Subdivision Comments

RE: SP-22-00004 Willard

HAYBROOK FARMS - PHASE 2
 PART OF GOV'T LOT 3, SECTION 30, T. 18 N., R. 19 E., W.M.
 AND OF THE E 1/2 OF SECTION 25, T. 18 N., R. 18 E., W.M.
 KITTITAS COUNTY, WASHINGTON

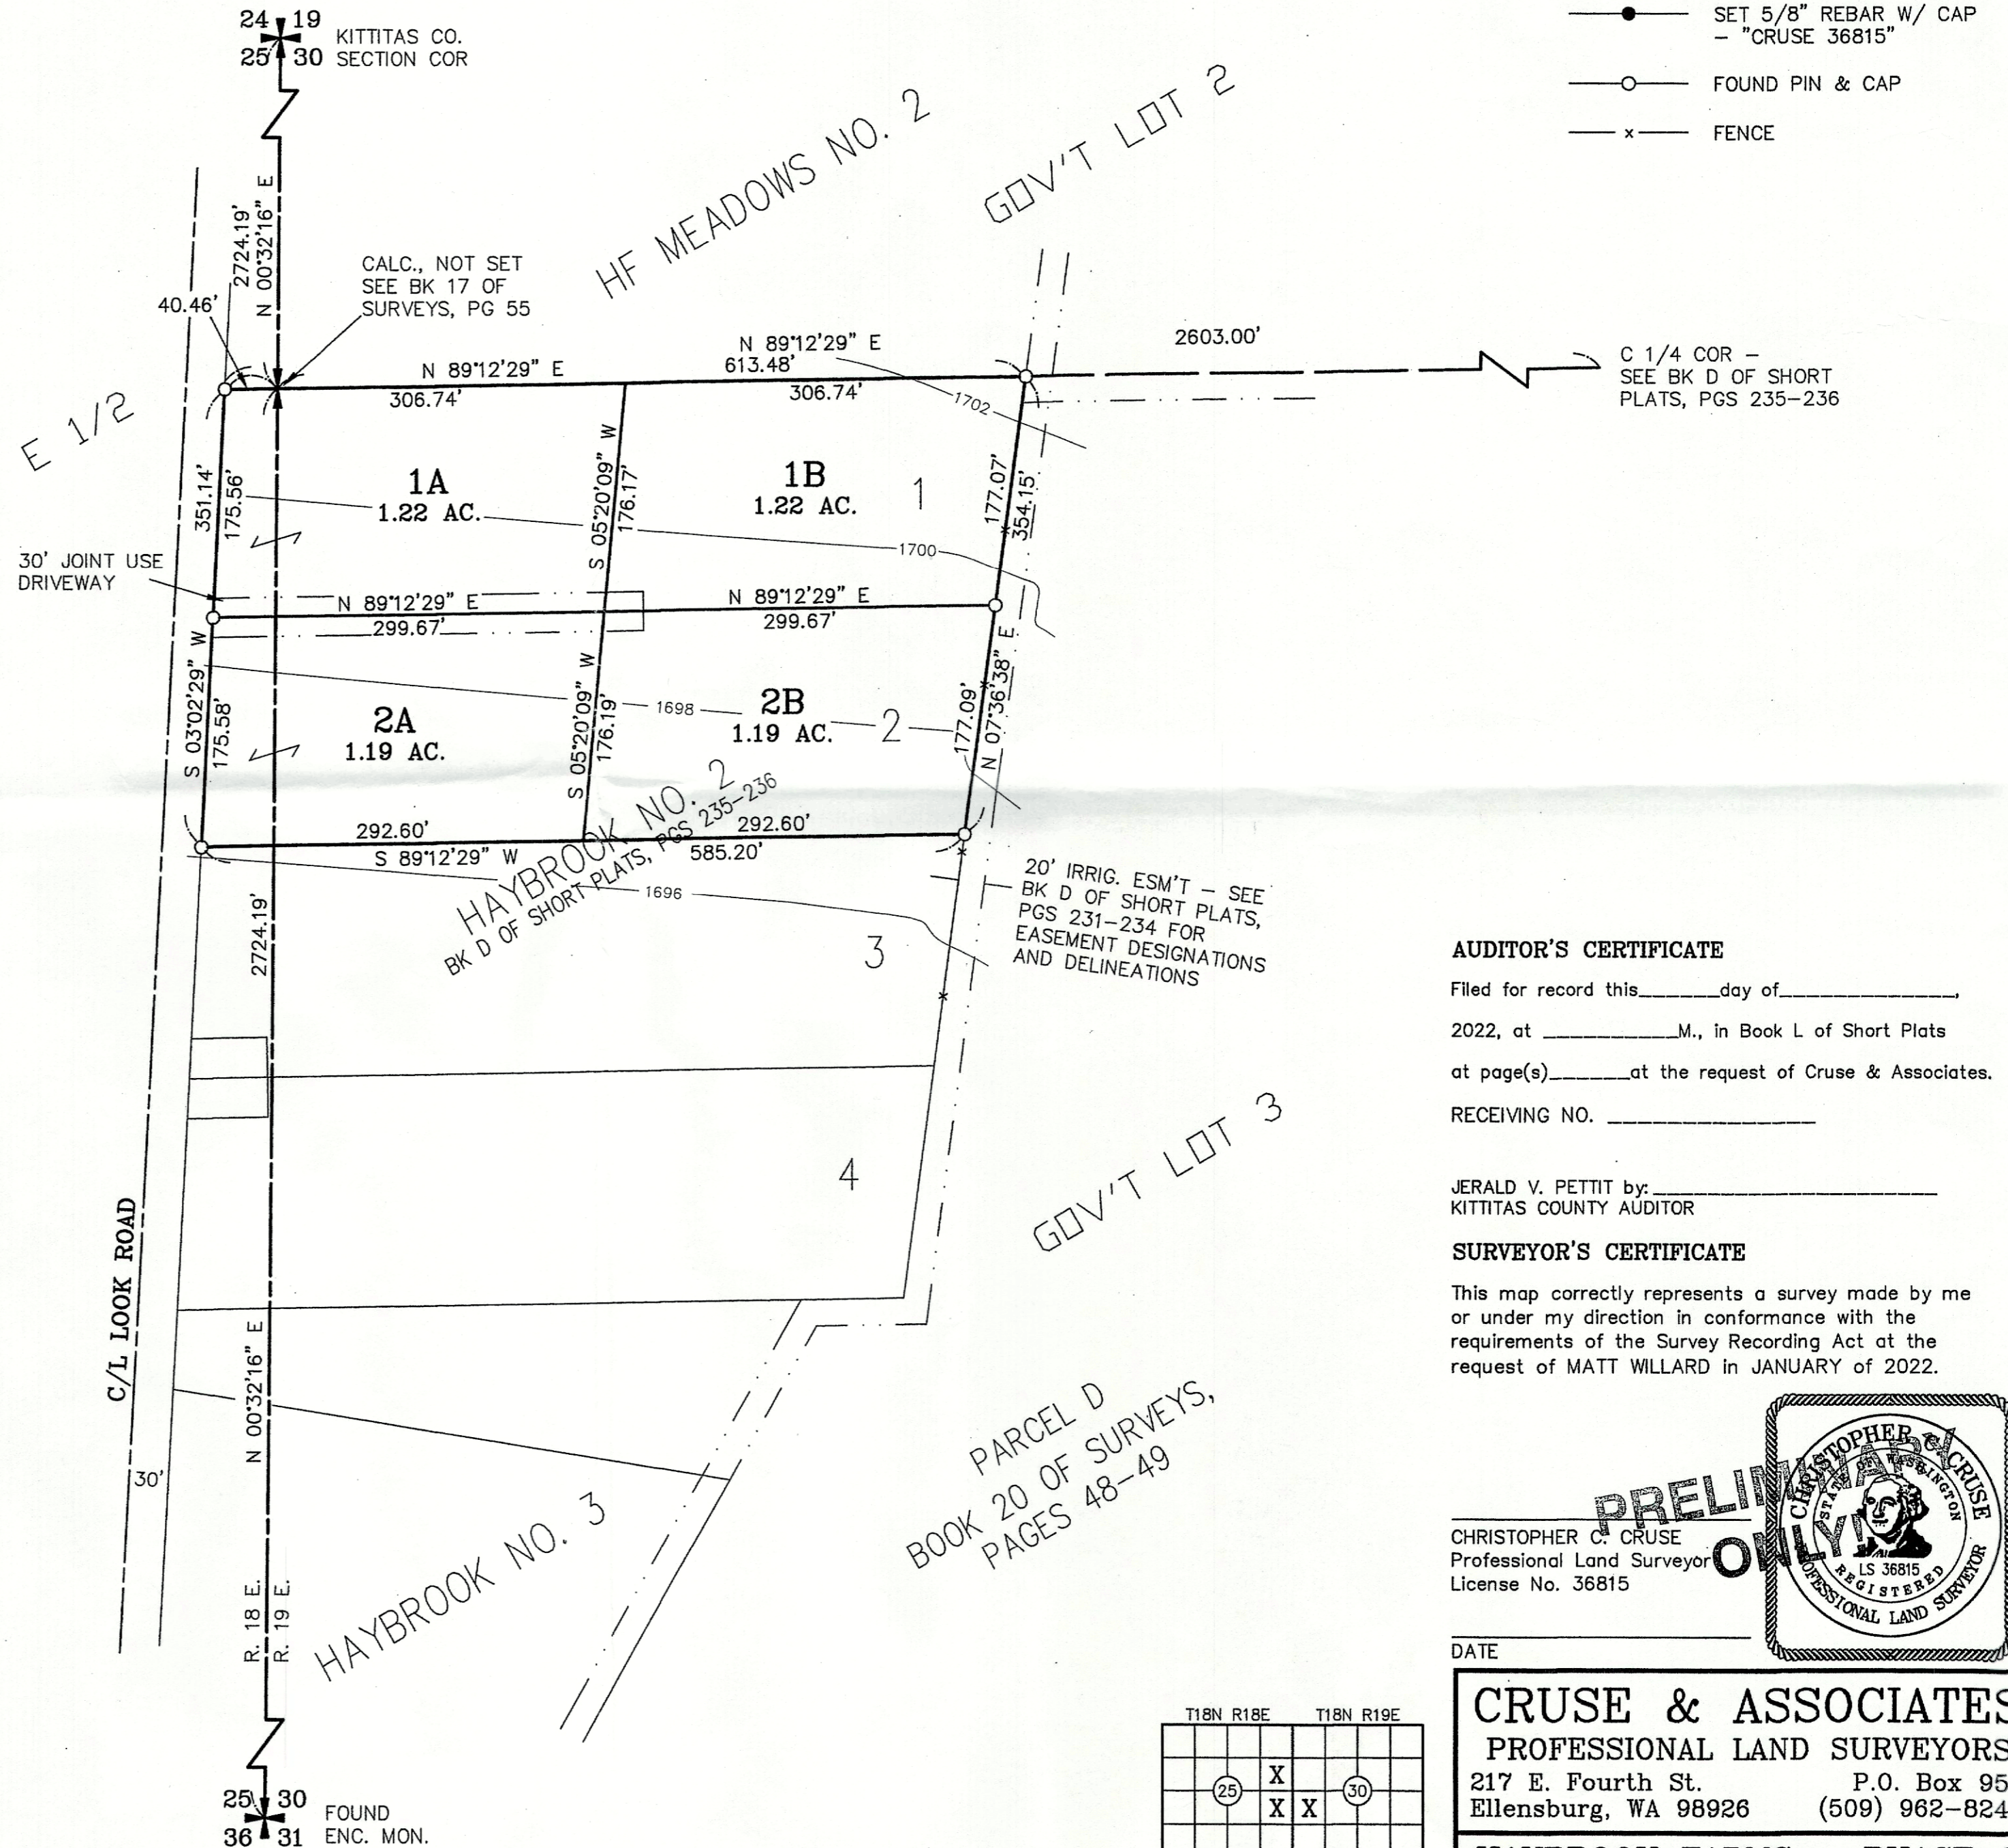
Any on-site septic systems that are to be utilized for wastewater management must adhere to the standards set by both the Washington Administrative Code, and Kittitas County Code. In accordance with KCC 13.04.090, a minimum of one soil log for each proposed lot where individual sewage disposal systems are contemplated must be completed.

The proposed short plat indicates the applicant will develop a Group B water system to serve the project. The location of the well site must be approved prior to drilling and a Group B water system must be approved by the Kittitas County Public Health Department. The applicant must prove legal and physical availability of water for all new uses of water on proposed lots.

A soil log must be done on each proposed lot.

A Group B public water system must be approved by the Kittitas County Public Health Department with a public water system ID# issued by the Washington State Department of Health, Division of Drinking Water.
